CITY OF ALBUQUERQUE

November 9, 2018

RE: **Apartment Urban Living @ Nob Hill
Central and Montclair NE
Conceptual Grading Plan Stamp Date: 10/29/18
Drainage Report Stamp Date: 10/29/18
Hydrology File: K17D073**

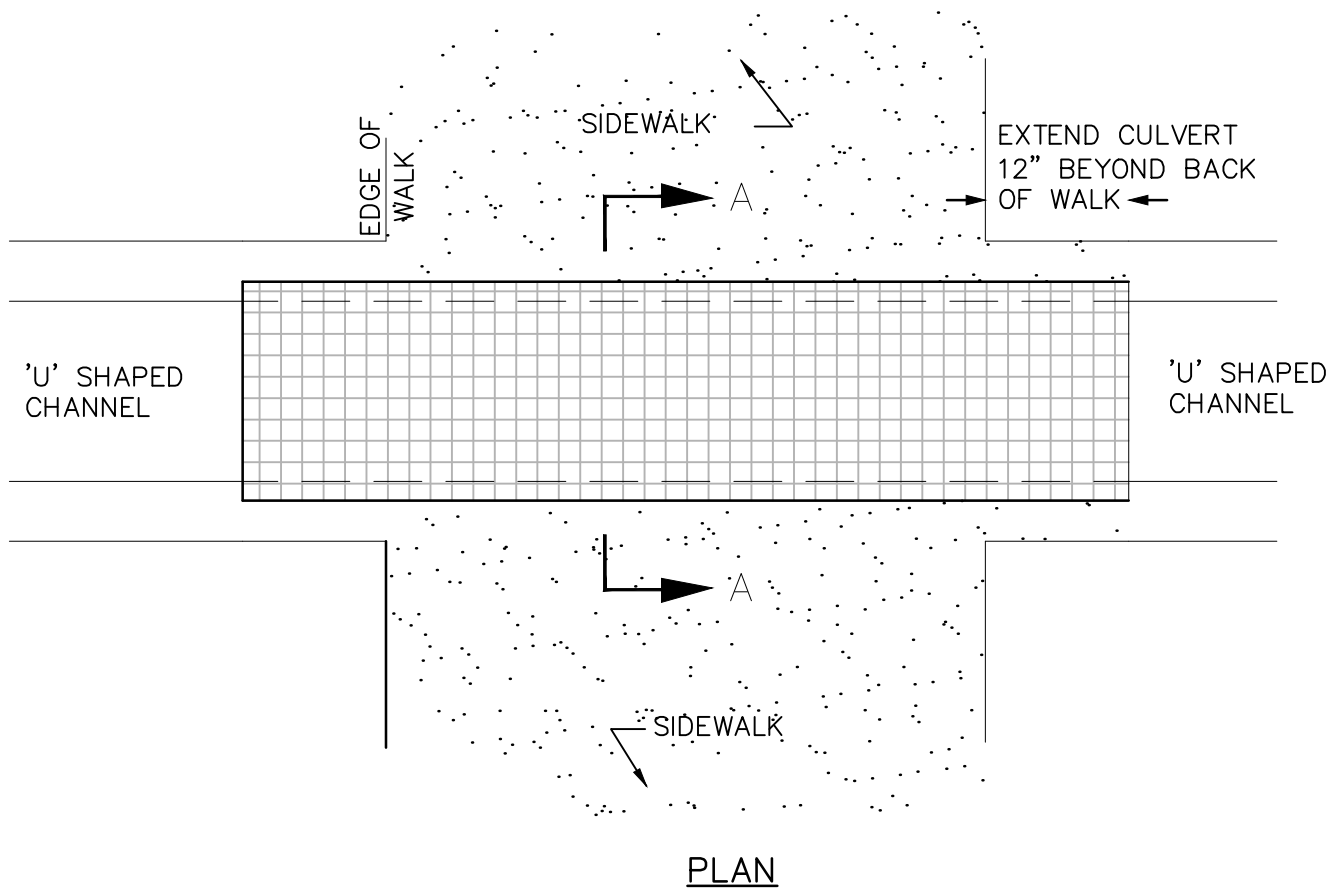
3. After reviewing the proposed channel on Copper in greater detail, we cannot allow in to be placed in the ROW; revise the plan and infrastructure list to just extend the sidewalk culverts out to the face-of-curb on Copper.

Chart at left provides calculations for each run x percentage of volume available below the bubble-up rim elevation

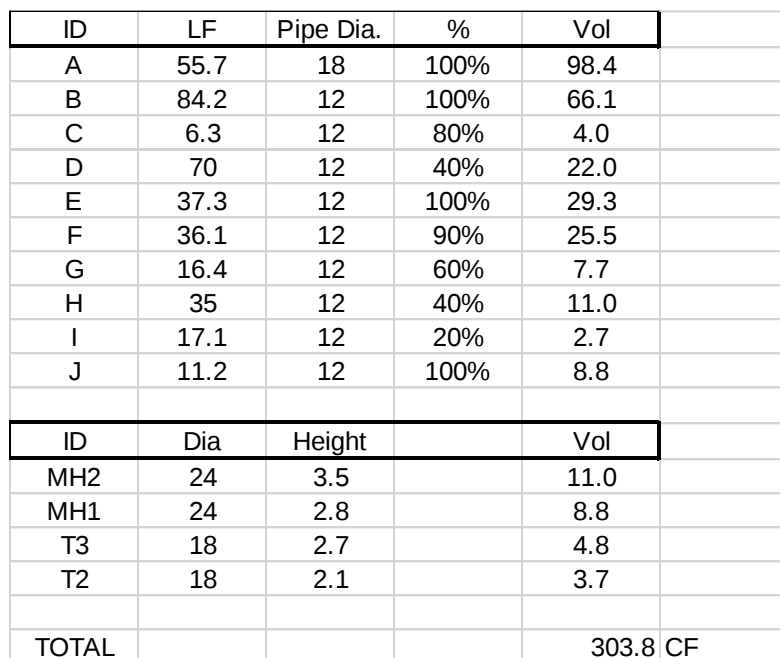
1. Storm water quality (SWQ) volume credit cannot be allowed for the volume stored in the pipes, unless those pipes are perforated and surrounded in gravel bedding for their respective lengths (a French drain). If you add gravel bedding, you can take credit for this pipe volume, plus the volume contained in the gravel voids using a porosity of 30% ($e=0.30$). Otherwise fee-in-lieu of the SWQ volume is required for the full amount of impervious area: ~83292sf.

Energy Grade Line Calculations*

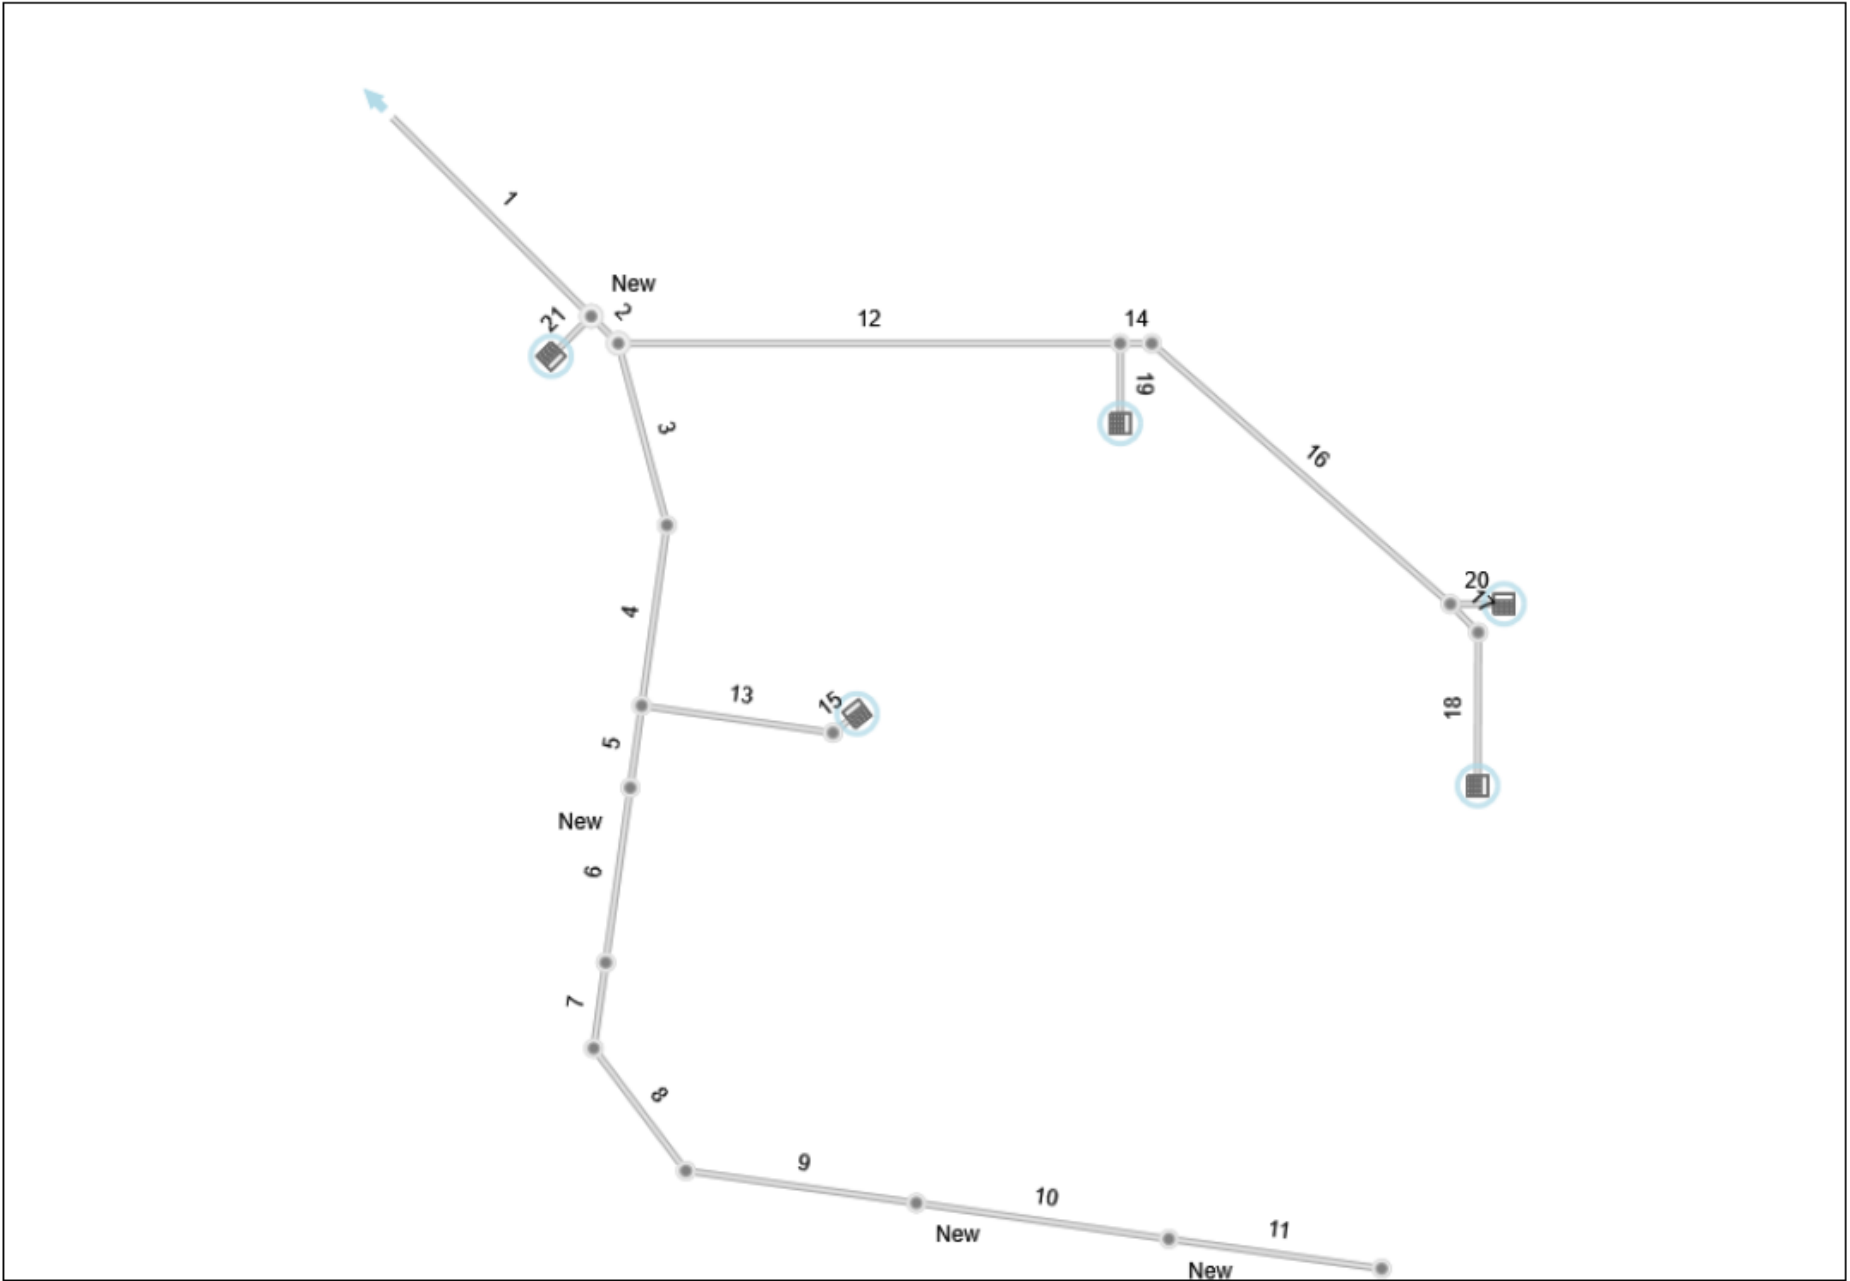
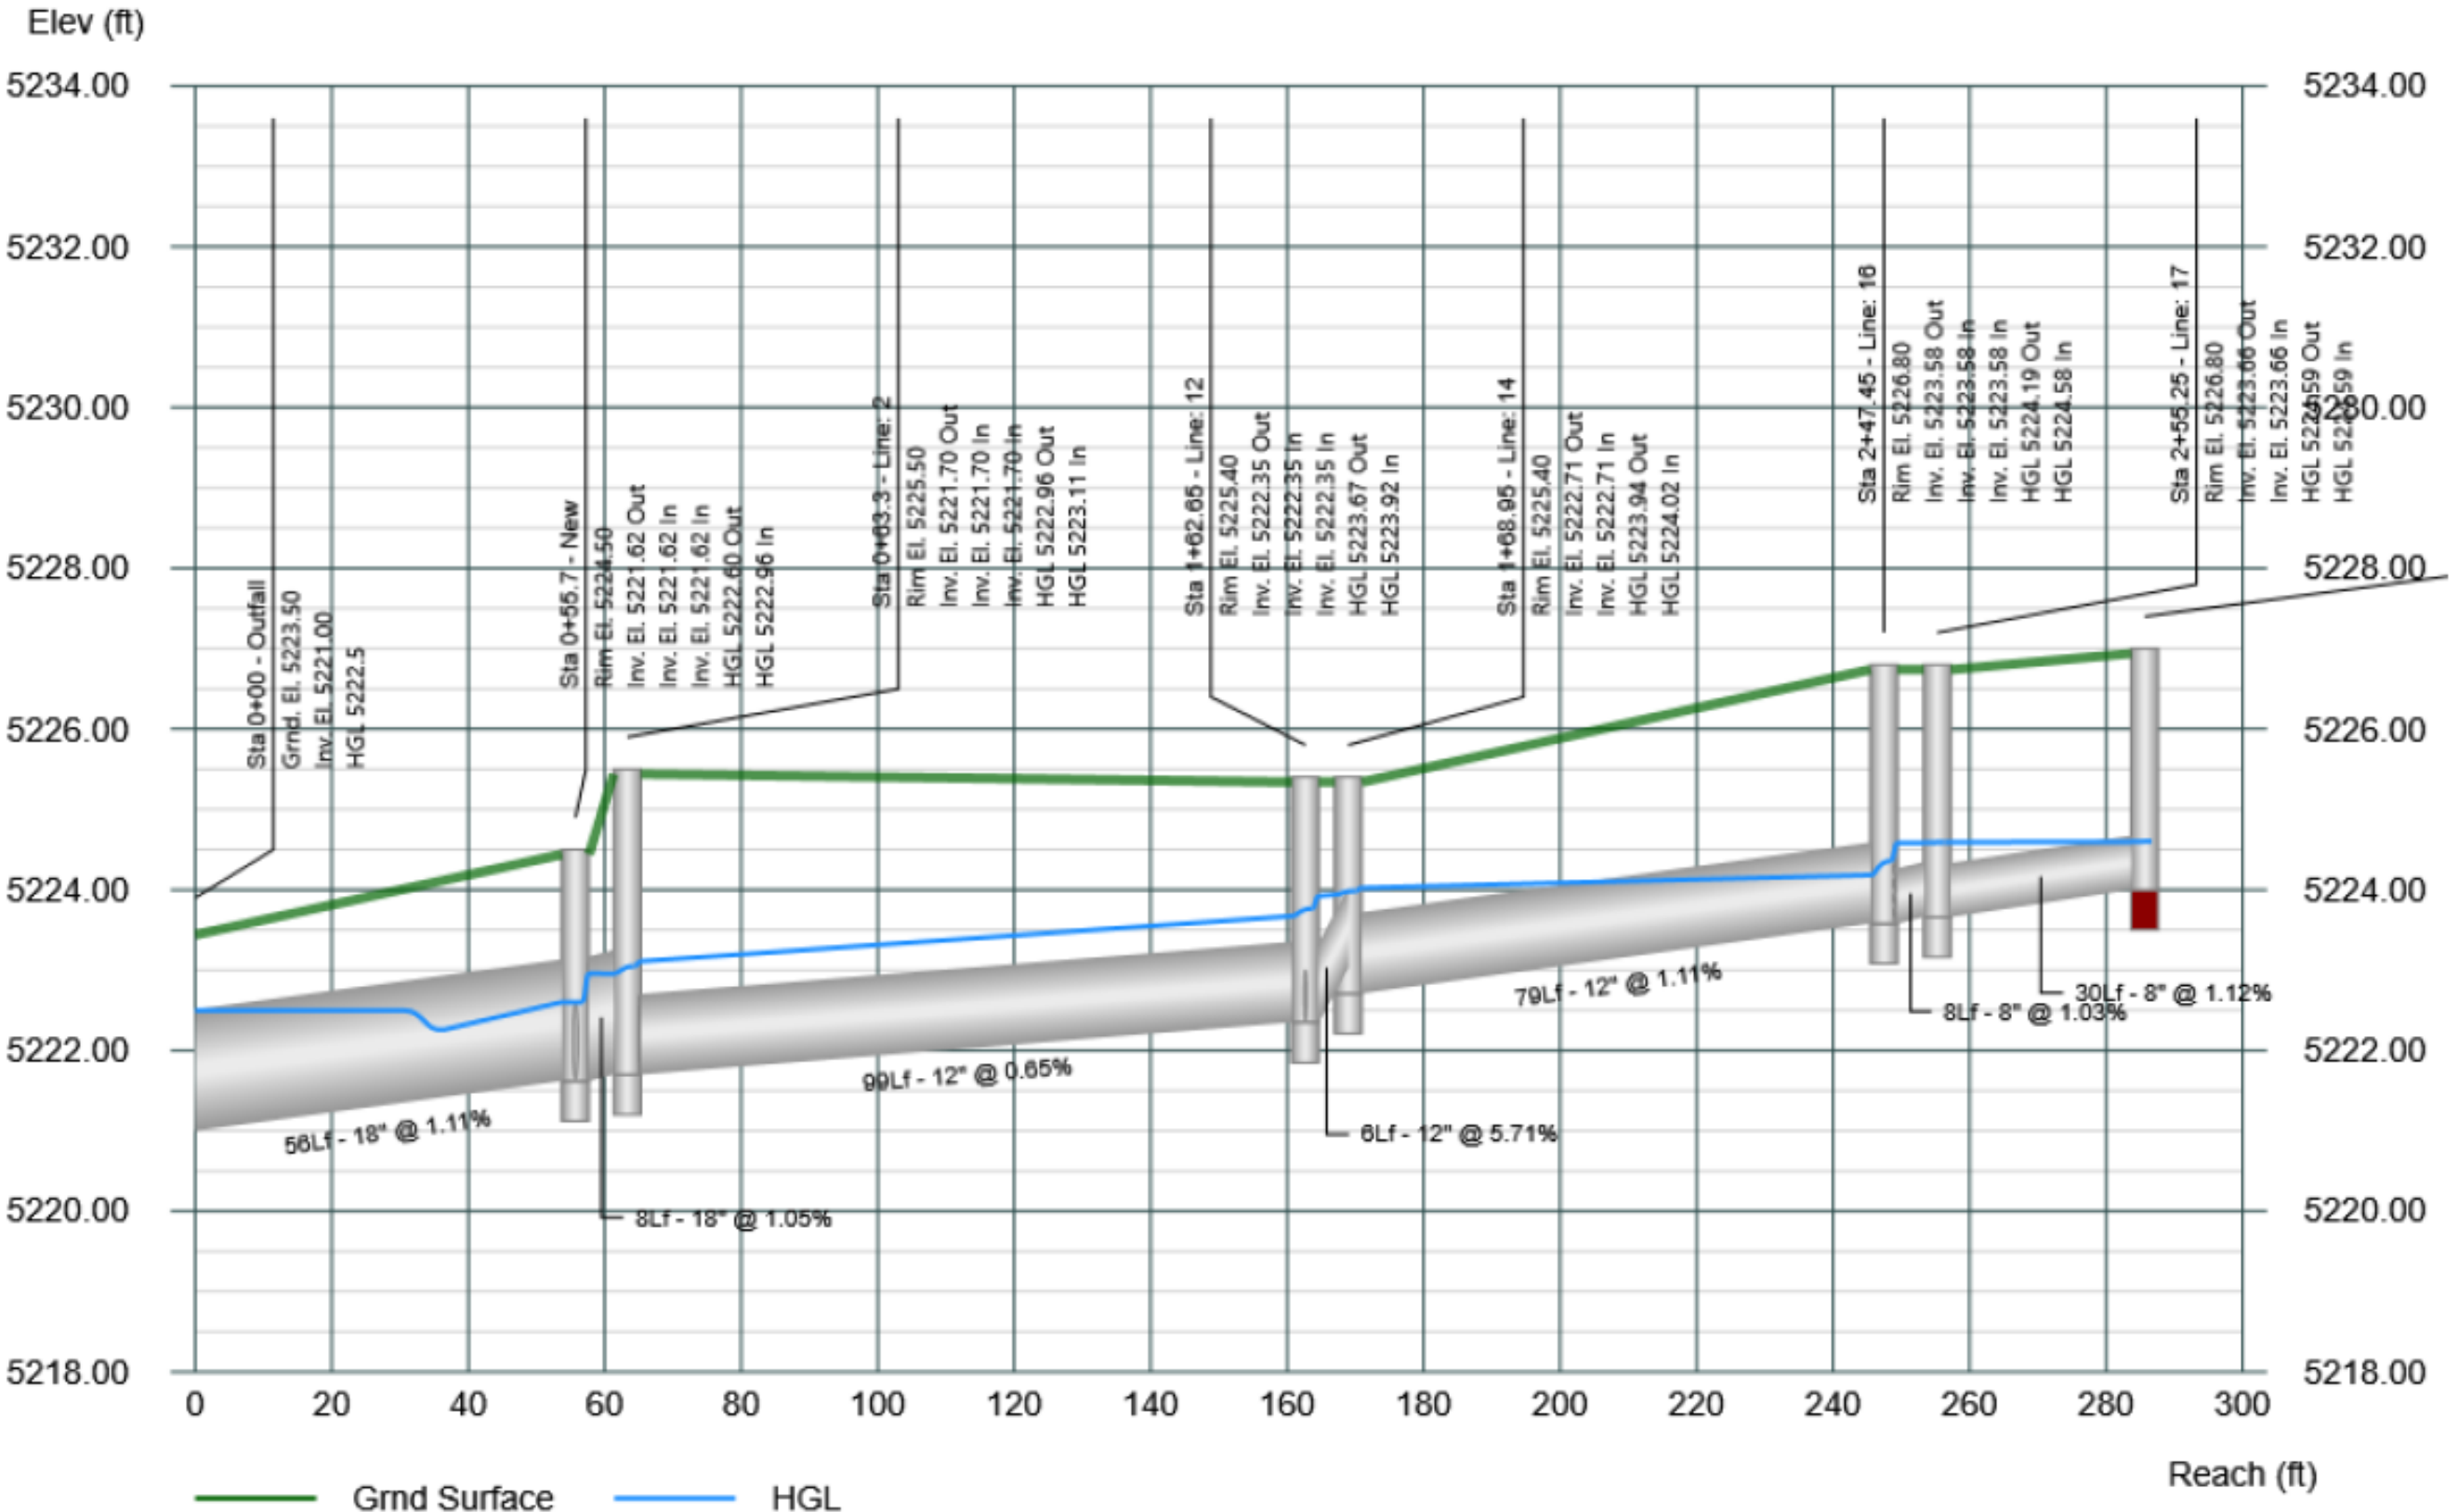
- d. The HGL output table provided did not have any of the results.
10. This project requires an ESC Plan, submitted to the Stormwater Quality Engineer (Curtis Cherne PE, ccherne@cabq.gov or 924-3420).
